**STORM WATER MANAGEMENT PLAN
FOR
NORTHGATE SUBARU
208 AND 309 GLENEAGLE GATE VIEW, COLORADO SPRINGS**

FEBRUARY 2025

County Job No. **TBD** PPR2514
Project No.

GRADING AND EROSION CONTROL PLAN  
INTERIM EROSION CONTROL PLAN

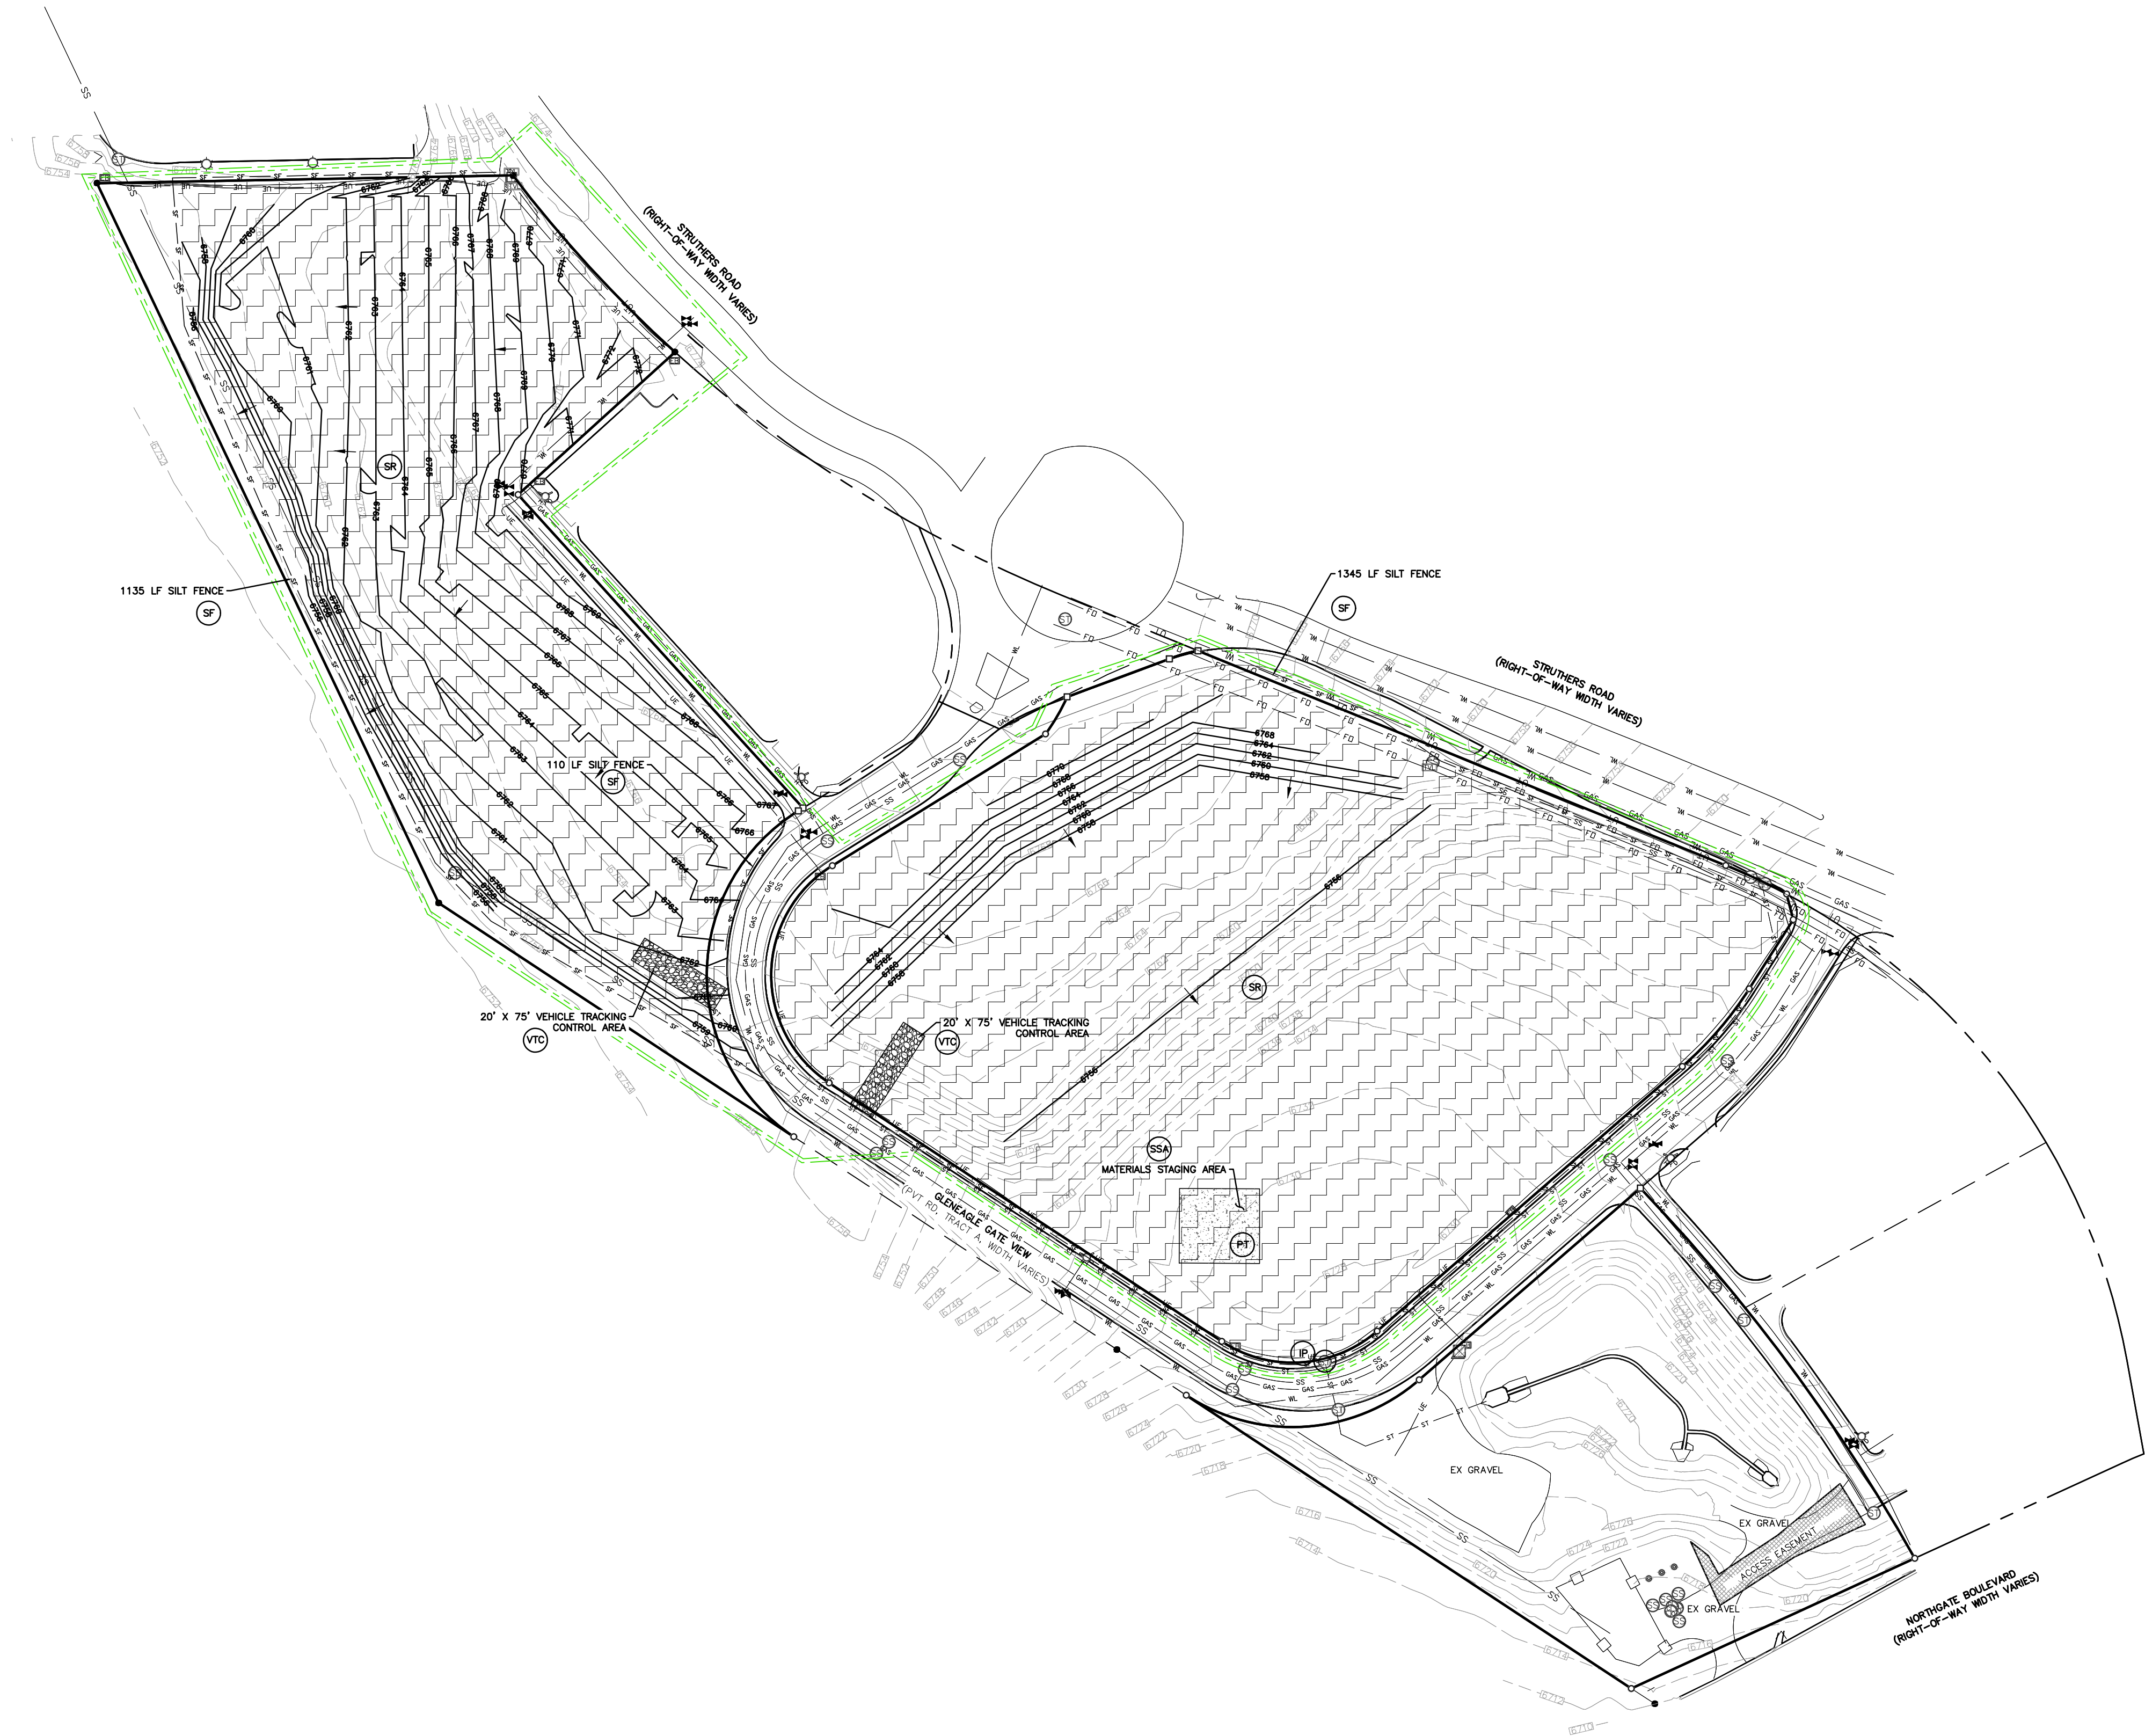
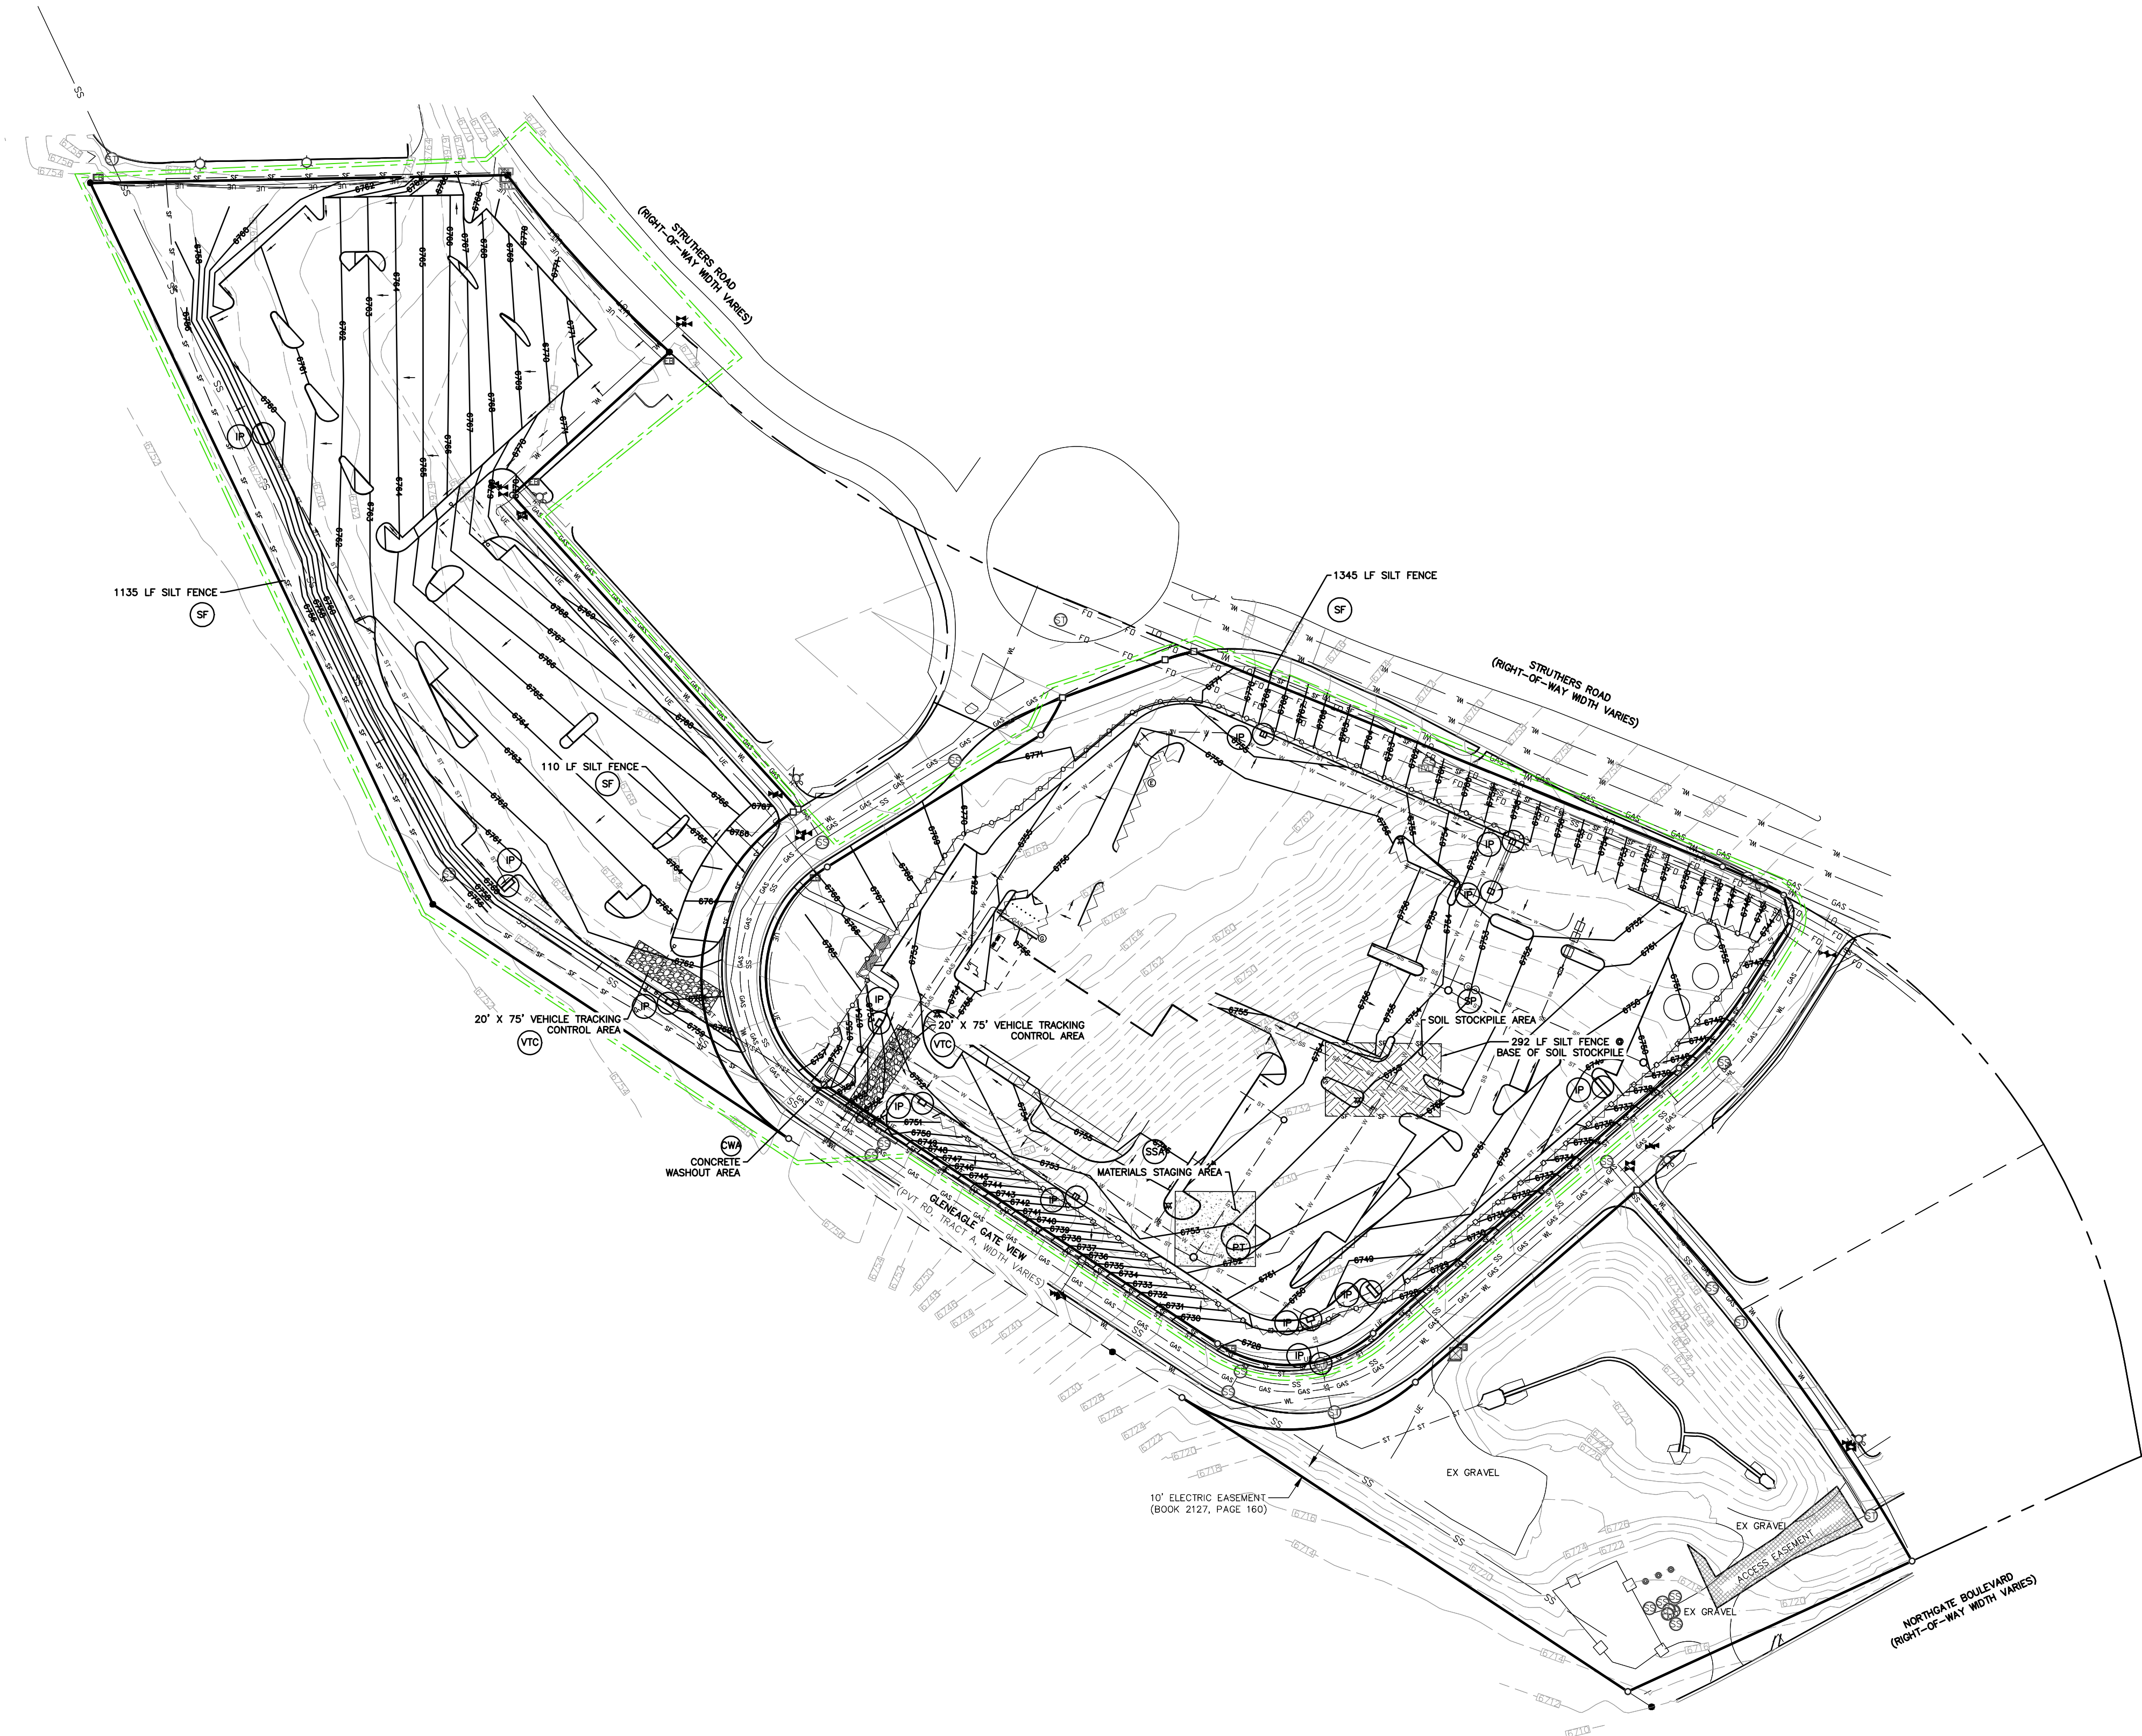
Item 14. Discuss Location and description of any anticipated allowable non-stormwater discharge. Discharge of concrete wash water to ground (e.g. a concrete washout area) is an allowable non-stormwater discharge per the COR400000 Permit if properly identified in the SWMP and if the appropriate control measures are implemented. Revise discussion. Reference COR400000 Part I.A.1.b.ii for more information if needed.
